**Application for a non-material amendment following a grant of planning permission,
Town and Country Planning Act 1990**

**Non material amendment to previous permission 2019/91657 for erection of 30
dwellings**

Land at Station Road, Skelmanthorpe, Huddersfield, HD8 9BA

Application Number: 2023/92773

HOUSE TYPE C2 - STATION ROAD, SKELMANTHORPE

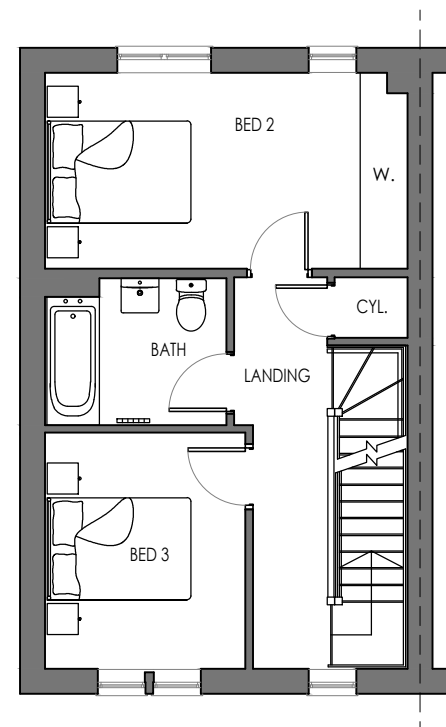
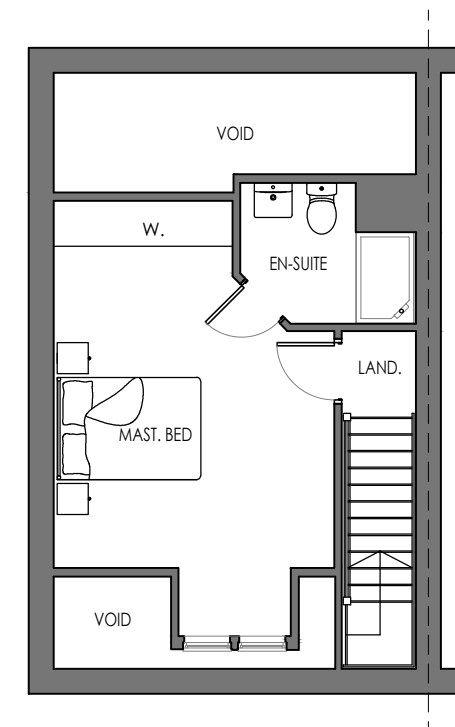
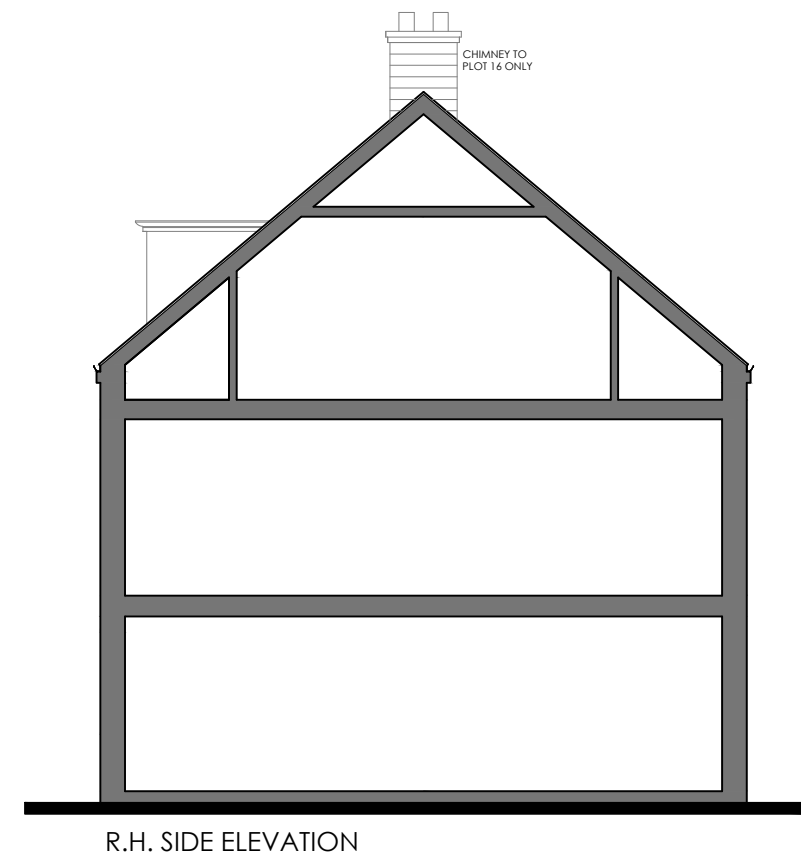
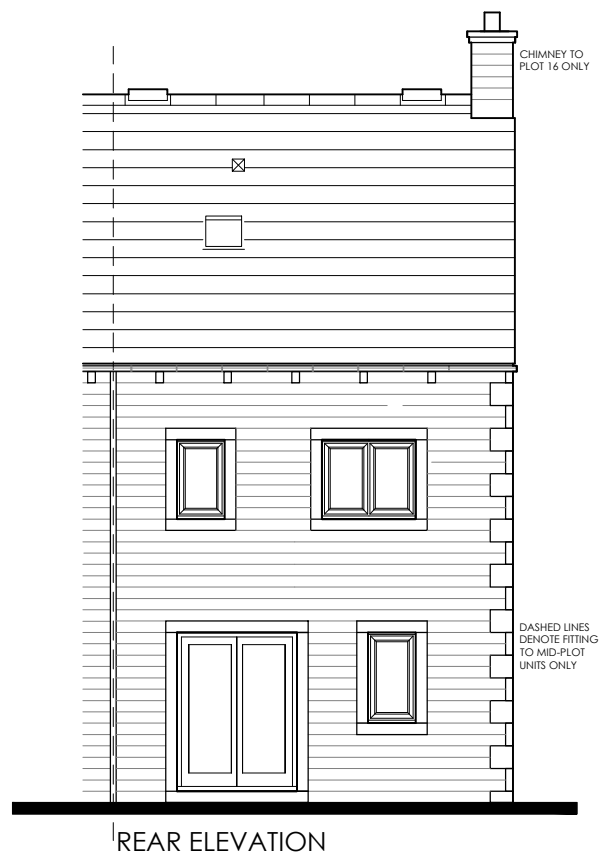
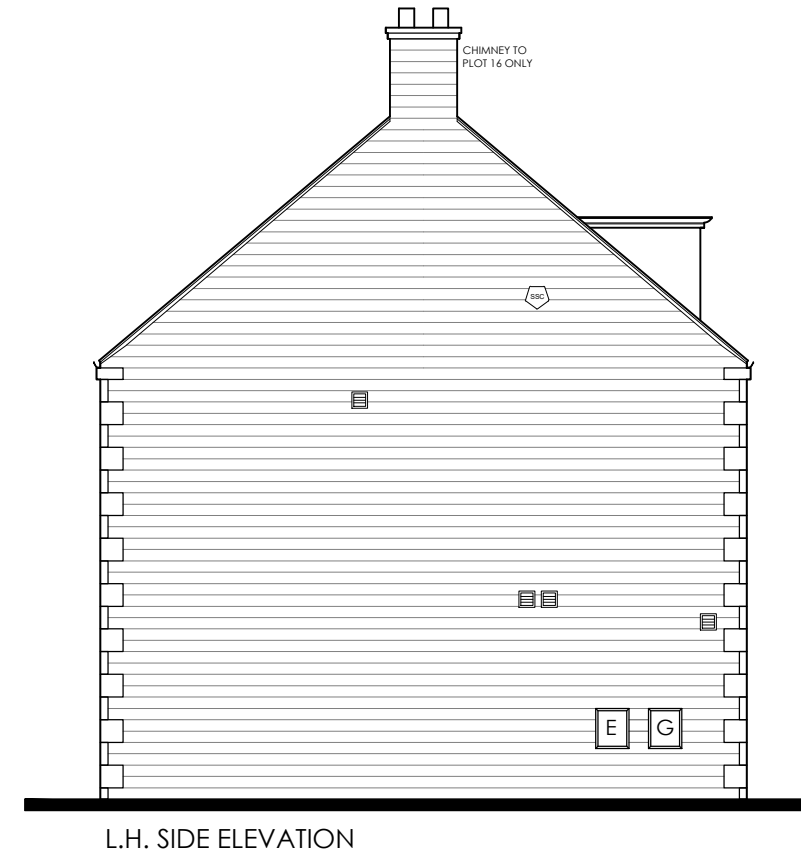
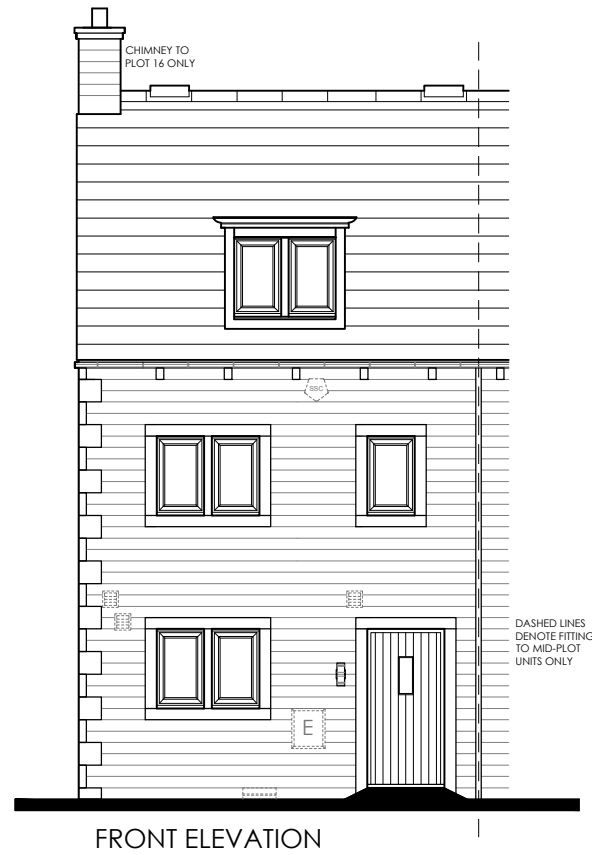
- Plots 16-18 (C2 type) – rear bifold door replaced with French door and window.
- Plot 28 (E type) – rear bifold door replaced with French door.
- Plots 19-22 (F type) – rear bifold door replaced with French door and side lights.
- Plot 25 (K type) – single-storey rear projection removed, window and door positions amended (also shown on site layout plan).
- Plot 26 (N type) – triple bifold door replaced with quad bifold door, and French doors to lounge replaced with triple windows.

I confirm that the alterations are acceptable and may be considered as a non-material amendment to the approved drawings. It should be noted that this letter relates only to the non-material amendment sought and it is not a re-issue of the original planning permission. The two documents should be read together and as such, all conditions imposed on the original granting of planning permission apply to the proposal as now amended. A copy of this letter and the amended plans will be retained on the public record of approved documents.
